Submission for Job: #6011 SSD 6011 - Mixed use residential development within the South West Plot
https://majorprojects.affinitylive.com/?action=view_job&id=6011

Site: #2825 SICEEP Site, The Haymarket; Darling Drive, Sydney
https://majorprojects.affinitylive.com/?action=view_site&id=2825

SSD 6011 - Mixed use residential development within the South West Plot

Submission by:

## Winter Solstice (21<sup>st</sup> June)

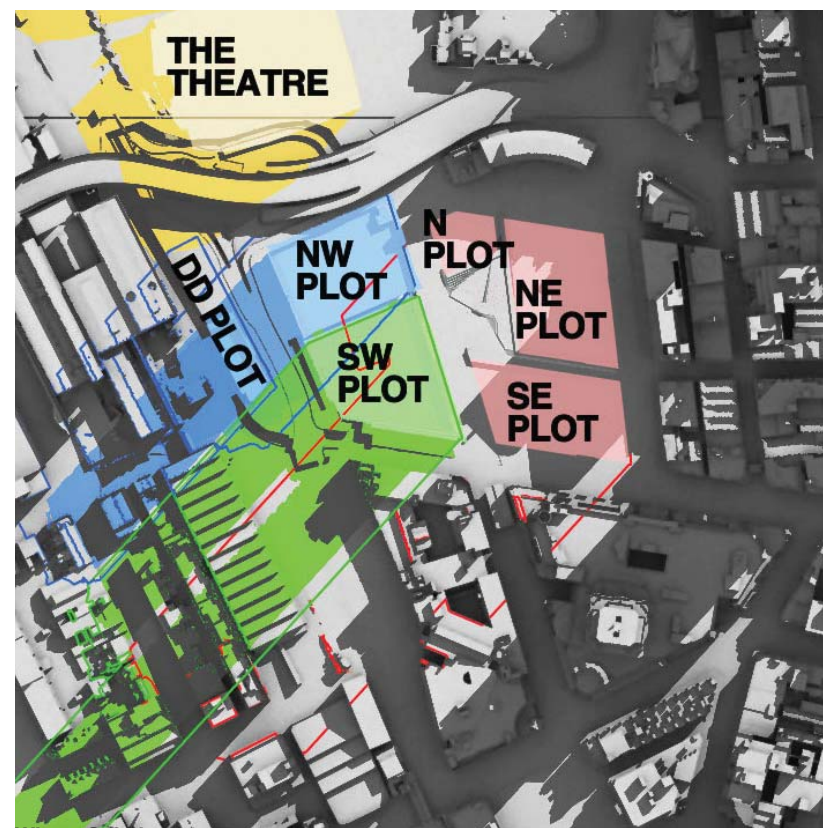
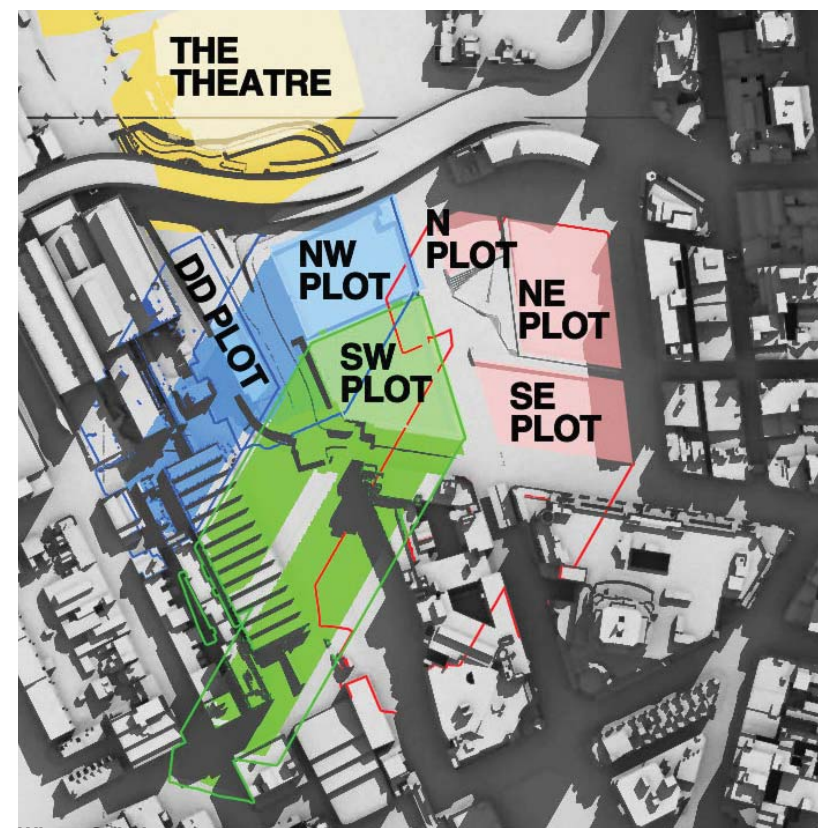
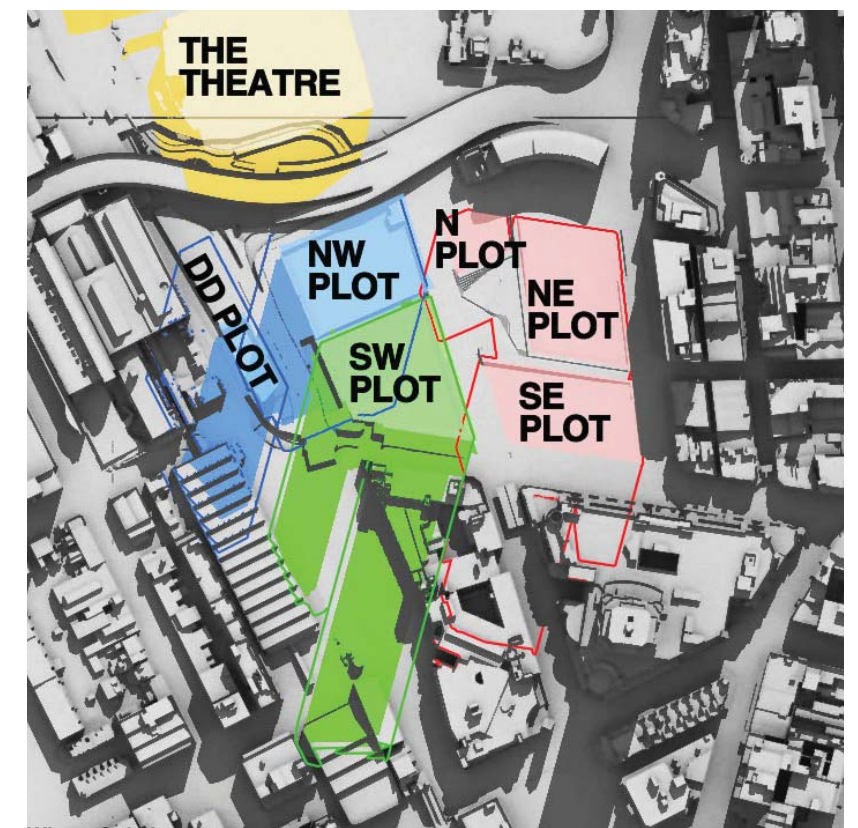
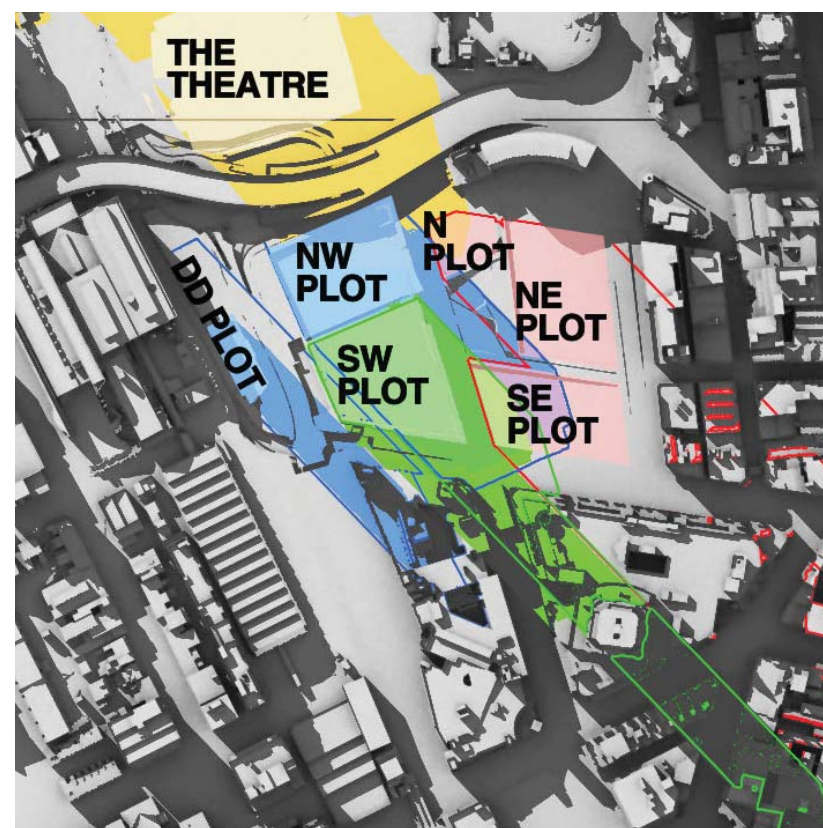
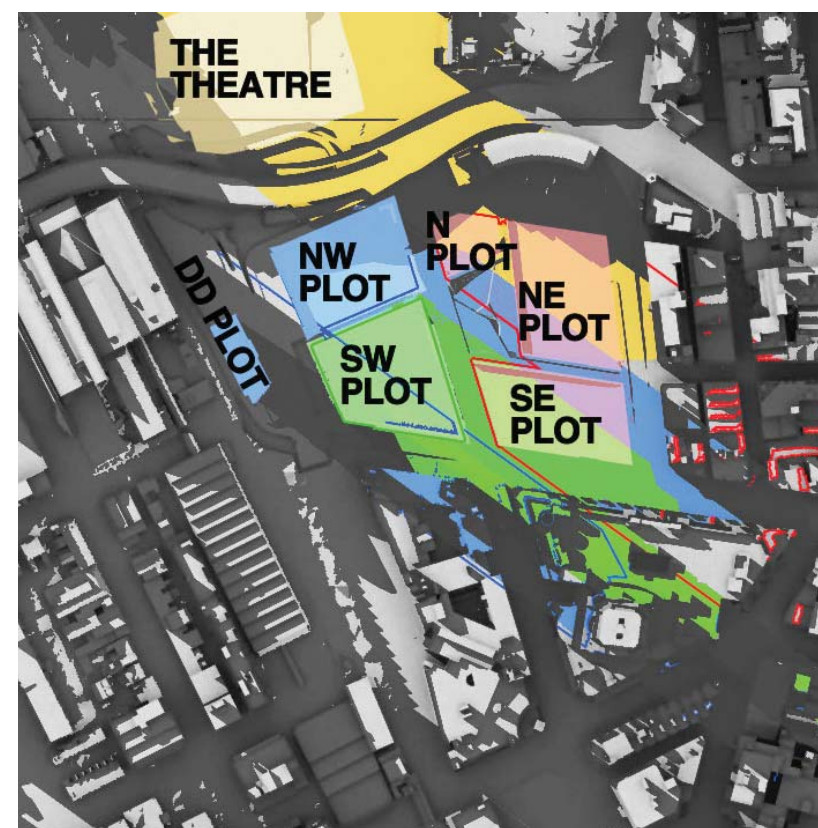
We refer to the shadow diagrams in SSD5878, Appendix H. Supplementary Design Report, Section 6. Amendments, Winter solstice - 22 June. This is not 21 June, but there would be no noticeable difference.

At 9am, 10am and 11am the west façade is totally in shadow due to other parts of The Peak building itself.

At 12pm there is still substantial existing shadowing on the west façade caused by the irregular shape of the west facade.

At 1pm the existing shadowing has been substantially removed, but not totally removed.

It can be concluded that some single aspect apartments on the west façade and some south-west dual aspect corner apartments currently receive less than 2 hours direct sunlight to habitable rooms and 50% of the private open space between 9am and 3pm on 21 June.

By 2pm the existing shadowing has been totally removed, but that is too late to achieve two hours of direct sunlight before 3pm.

At 9am, 10am and 11am the west façade is totally in shadow due to other parts of The Peak building itself.

At 12pm there is still substantial existing shadowing on the west façade caused by the irregular shape of the west facade.

At 1pm the existing shadowing has been substantially, although not entirely, removed. However, overshadowing of lower levels of the west façade by the concept proposal parameter plan shadows for the N,NE and SE plots has already started.

By 2pm the existing shadowing has been totally removed. However, overshadowing of the west façade by the SSDA4 and SSDA5 buildings has appeared and risen further up the west façade than the concept proposal parameter plan shadows for the N,NE and SE plots, which is still present.

At 3pm, the proponent states correctly that 45-45% of the western façade is overshadowed by the SSDA4 and SSDA5 buildings.

It can be concluded that, as a result of combination of the proposed development with existing shadowing of the west façade, some single aspect apartments on the west façade and the south-west dual aspect corner apartments which currently receive less than 2 hours direct sunlight to habitable rooms and 50% of the private open space between 9am and 3pm on 21 June will suffer additional overshadowing. It is beyond our skills to count the number of such apartments. We note that the proponent has made no attempt to do so.

Rather than counting the number of units which will not meet the DCP guidelines, the proponent attempts to trade-off direct sunlight at 4pm for lack of direct sunlight during the period 9am to 3pm. There is no provision in the DCP guidelines for such a trade-off.
